City of Albuquerque

September 27, 1985

RE: REVISED DRAINAGE PLAN FOR 4TH STREET COMMERCIAL BLDG. (J14-D53)
RECIEVED AUGUST 14, 1985

APPROVALS	NAME	DATE	TITLE: COMMERCIAL BLD. 1223 FOURTH ST. N.W. ALB. N.M.
A.C.E./DESIGN			PORT BLOCK 5 ROMERO ADDN
INSPECTOR			ROBERT LUEL 600 1st ST NW SUITE 100
A.C.E./FIELD			PERMIT NO.
			SHEET 3 OF 3
			MAP NO. J-14

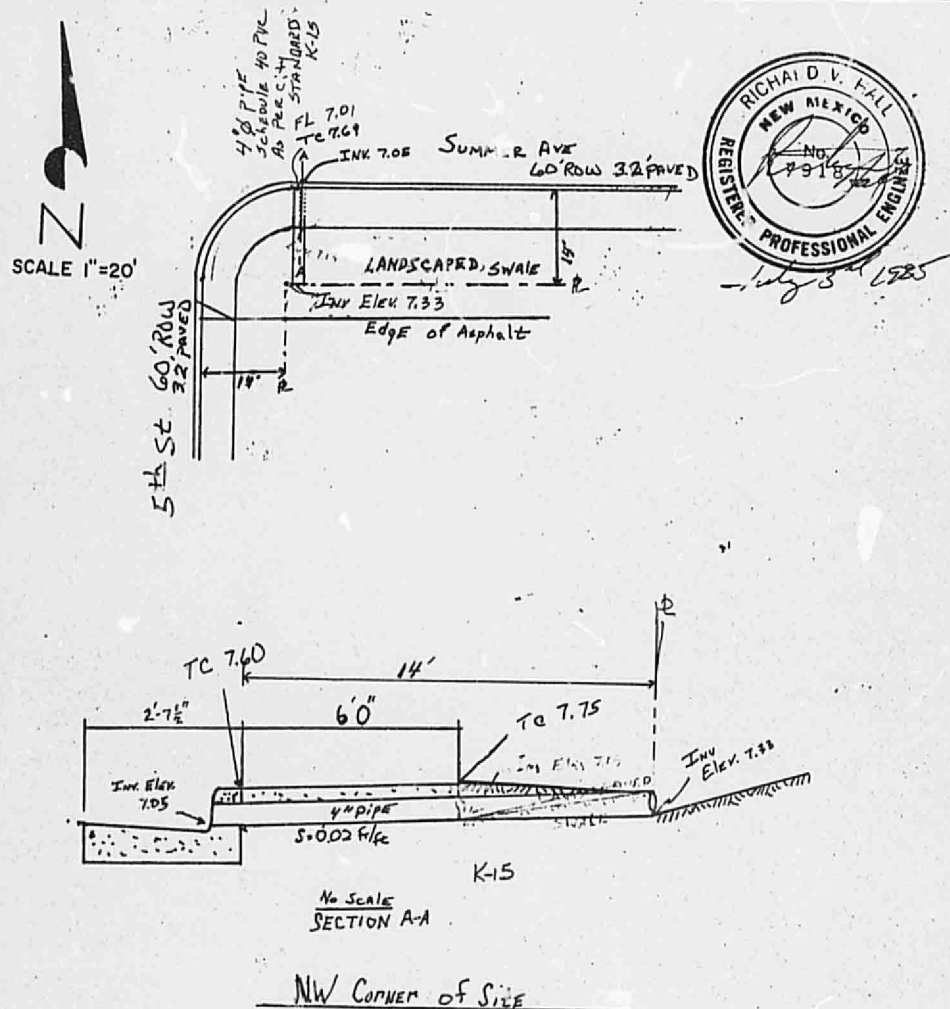
1. It is not very clear as to what is being constructed but I am assuming that it is for the parking lot in the north portion of lots 19-24 of the block and including the alley. If this is correct then a paving permit issued by only this section is appropriate.
2. The drainage analysis for this site is approved. However, prior to Hydrology sign-off the City approved alley grades and improvements will be required. The reason for this requirement is due to the dependency of this site for the use of this alley. Also, the note for erosion control is not appropriate. The note does not provide for a means to keep the exposed soil, during construction, from being wash into the City R/W. A more definitive plan will need to be established for approval.
